**WINTER ORNITHOLOGICAL SURVEY LOT No.1:
MOUNTDILLON, DERRYAROGUE, DERRYADD, DERRAGHAN
(BY MALACHY WALSH & PARTNERS, 2015)**

A REVIEW OF SURVEY COVERAGE AND METHODS.

Prepared for,
Tobin Consulting
Engineers
6th May, 2016

Overall bog Boundaries and Vantage Points

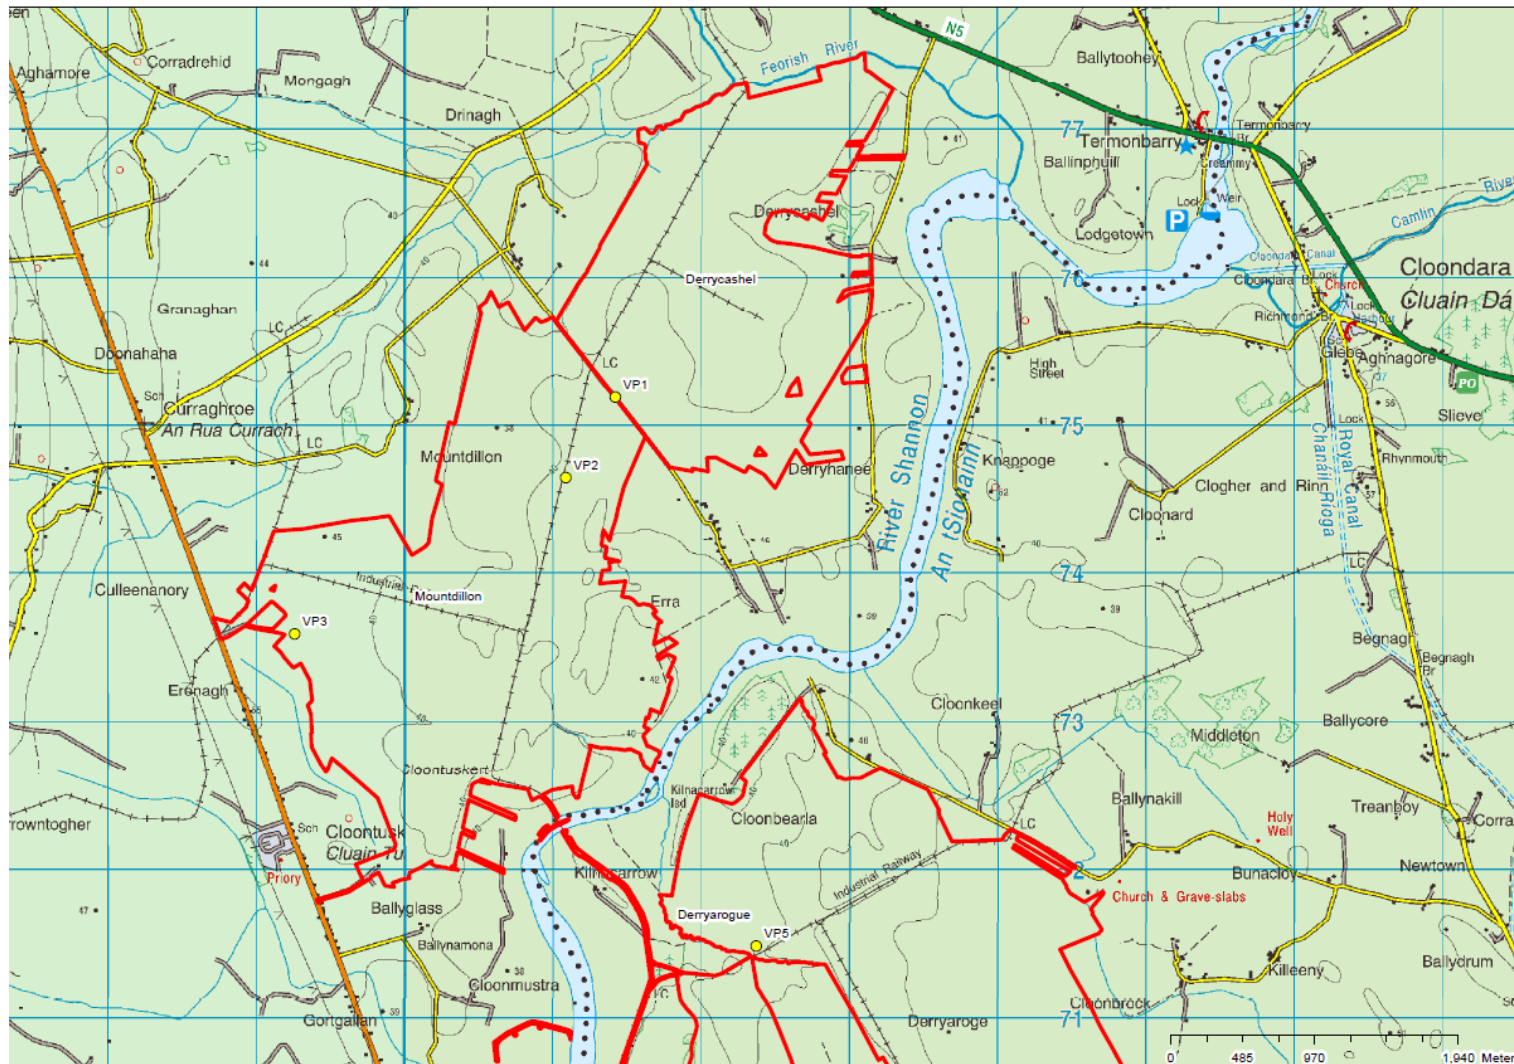
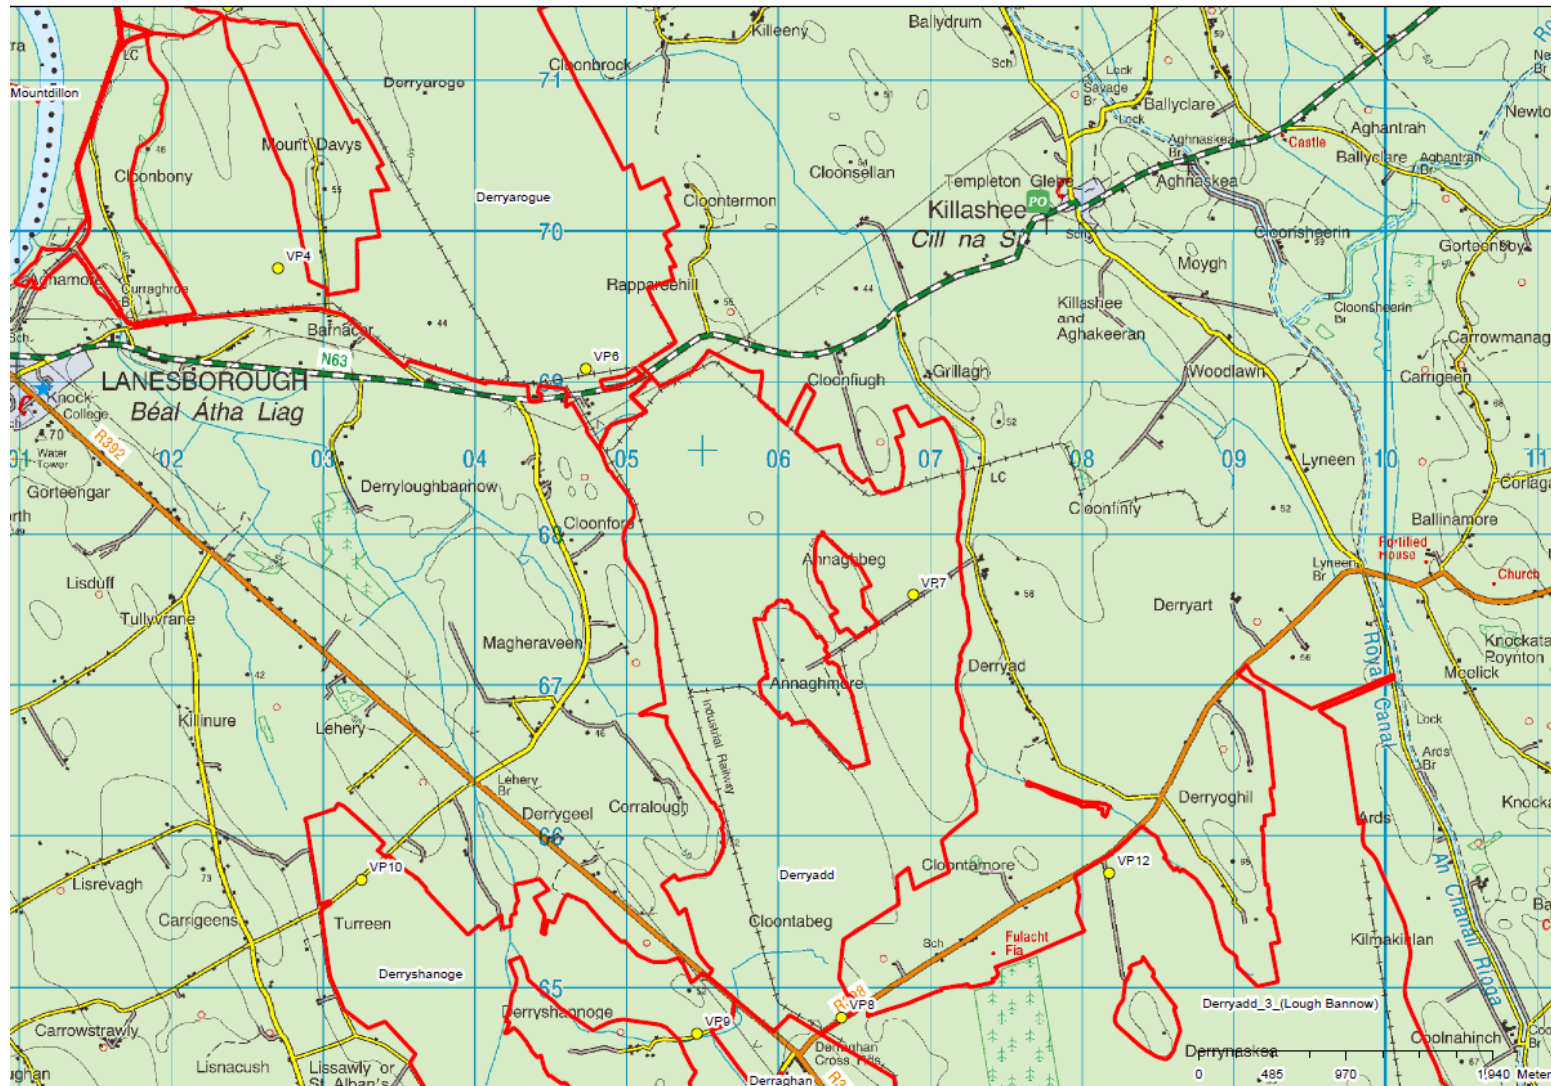
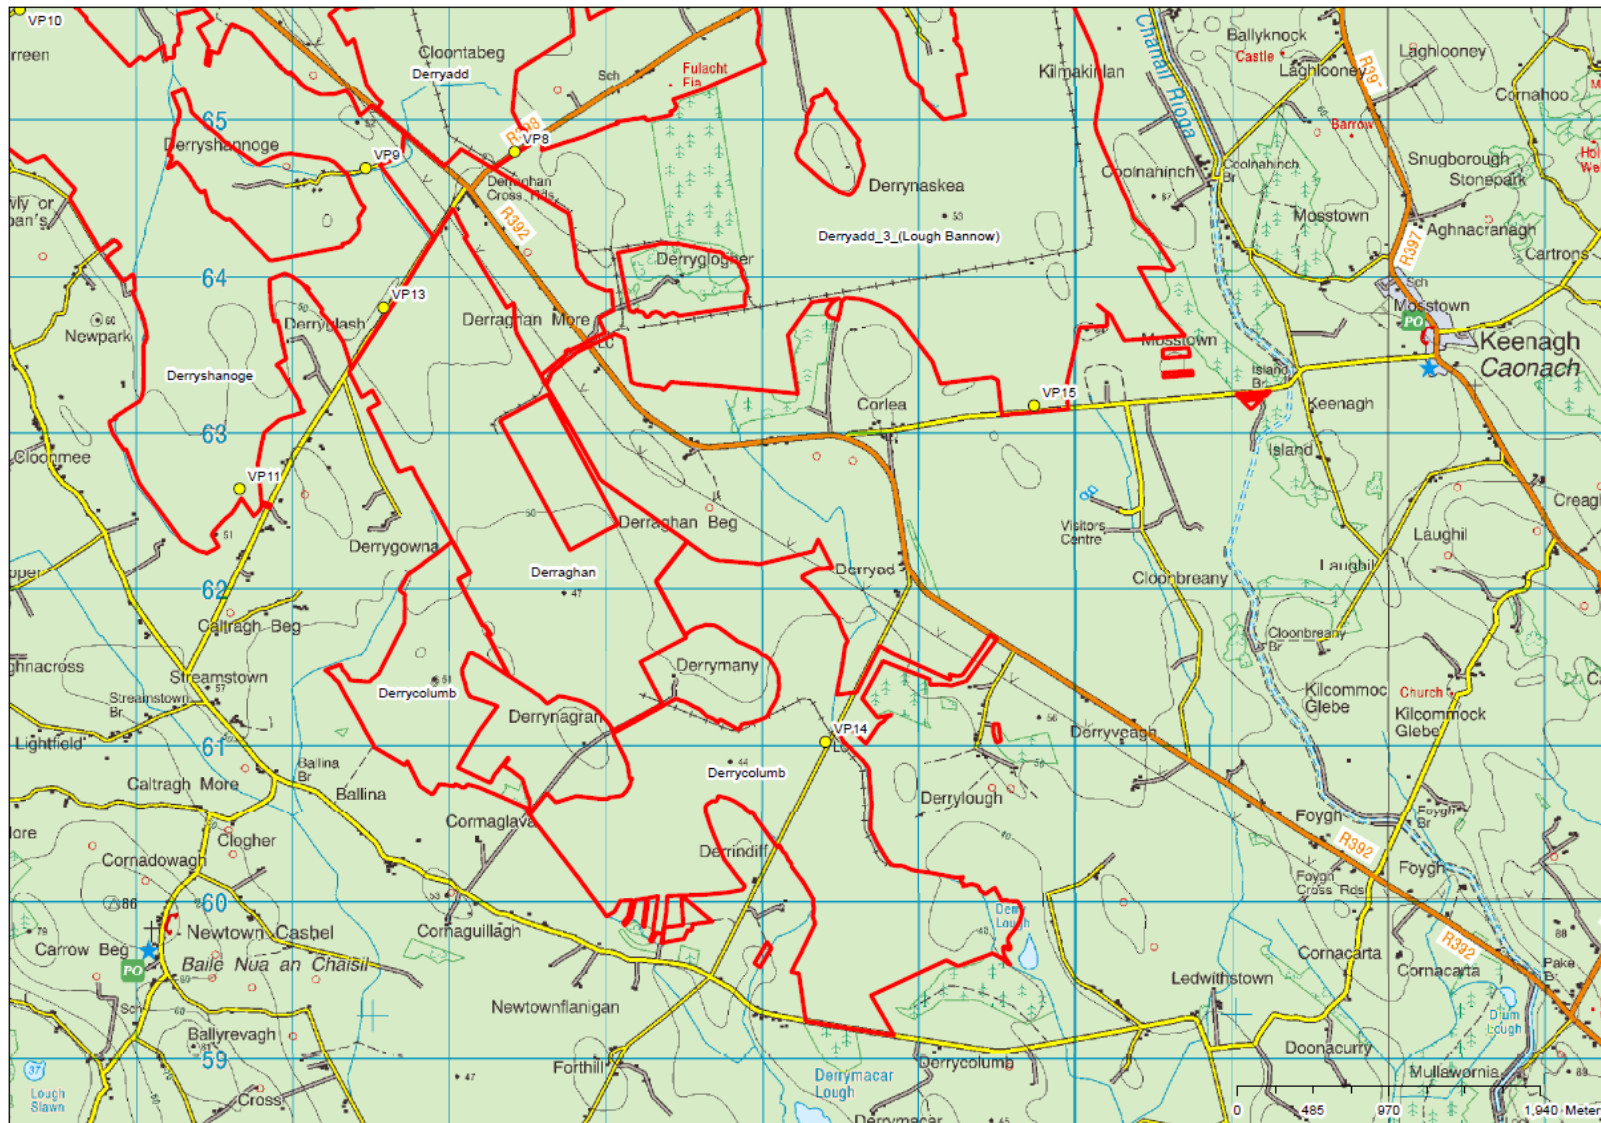
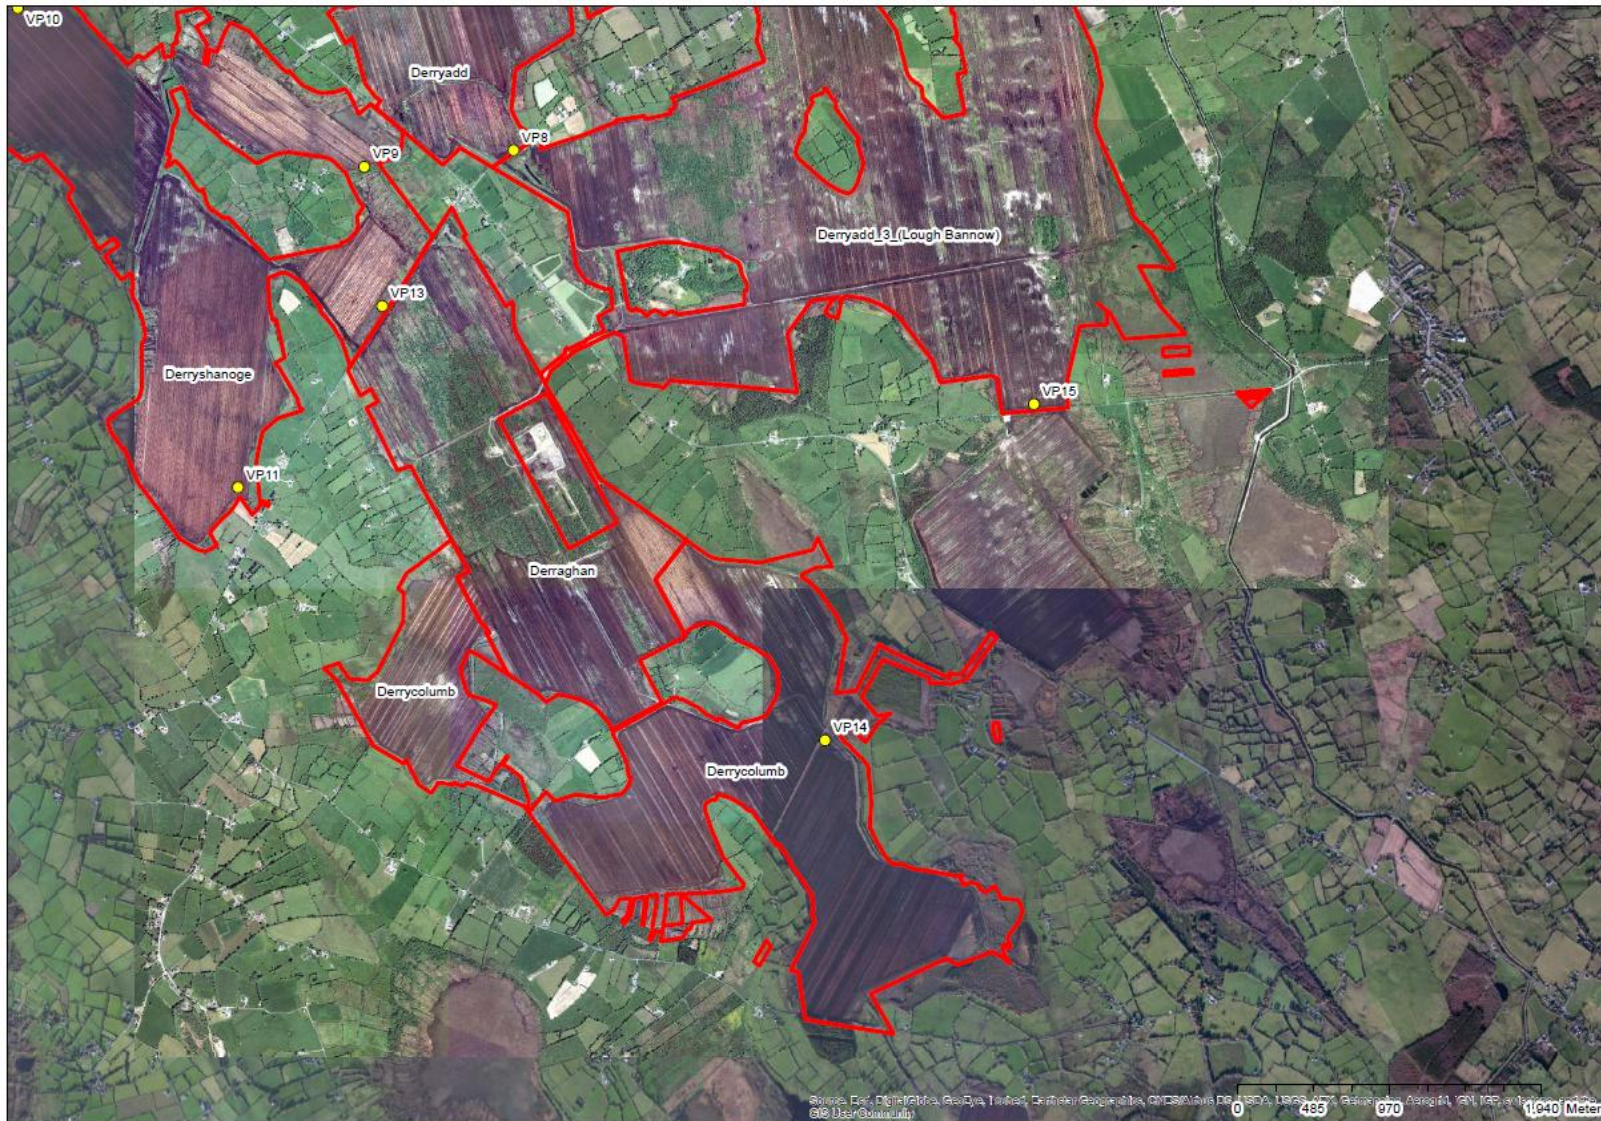
SNH recommend that each VP should give the surveyor a 180 degree viewing arc over the site. The surveyor scans this 180 degree arc continuously; this is the survey area of the VP. The field of view maps show that some VPs cover more than a single 180 degree arc, however it is not clear if two watches are completed at the VP, or just one which covers views both ahead and behind. For future surveys it is important to ensure that each VP covers a single 180 degree arc, for 6 hours per month throughout the winter season. If a VP is covering views both ahead and behind the observer, then two VP watches at this location may be required.

In addition to the provision of field of view maps, proper Viewshed analysis should be completed. This should take into account the combination of field of view and topography to allow the reader to clearly see what areas are visible to the observer. This analysis is also required to inform collision risk modelling.

The field of view maps show that not all of the site is covered by the current VP locations. This means that there is no survey coverage to establish use for some parts of the site. The largest gap is between VP 13 and 14, but there is also an important gap between VPs 1, 2, 3 on the north side of the Shannon River and VPs 4, 5 and the south side. Additional VPs may be required to cover parts of the site which are not in view from any VP. Unless a rationale can be presented for not covering these areas (unsuitable habitat for example) then this is a weakness in the survey coverage

- Complete additional VP watches during Spring and Autumn migration.
- Improve VP coverage of site. Additional vantage points may be required to cover areas not viewed by current VPs (as shown by field of view maps).

- Complete view shed analysis. This should be done to reflect ground level view shed and at 30m and 50m bands, which are potential lower sweep-zone heights of typical turbines.
